Your ref:
Our ref: 22/01308/CU
Please ask for: Mrs Joanne Rahman
Direct dial: 01553 616233
E-mail: borough.planning@west-norfolk.gov.uk

26 July 2022

Details: **Change of use of buildings to private use to house own horses and personal belongings (no alterations to buildings) at The Stables East Winch Road Blackborough End Norfolk PE32 1SF**

GROUND FLOOR

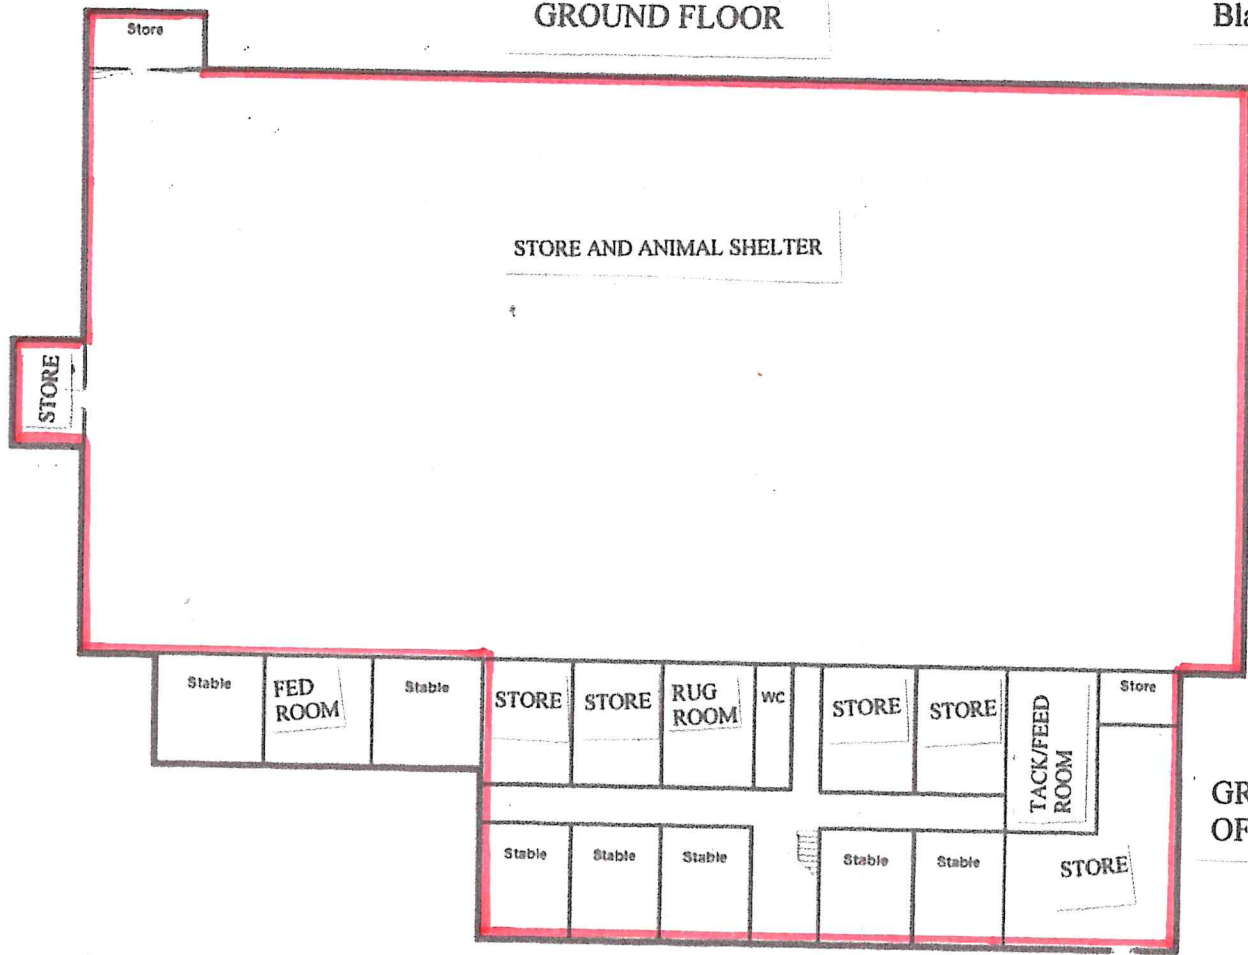
1. There is a store on the side of the building that is included in the red line of your floor plan but it is not within the red line on your location plan. Please amend your location plan so that all of the building subject to the change of use is included in the red line and and resubmit this plan.
2. Thank you for your floor plan but this has not been done to the correct scale. Please submit floor plans done to a scale of 1:50 or 1:100.
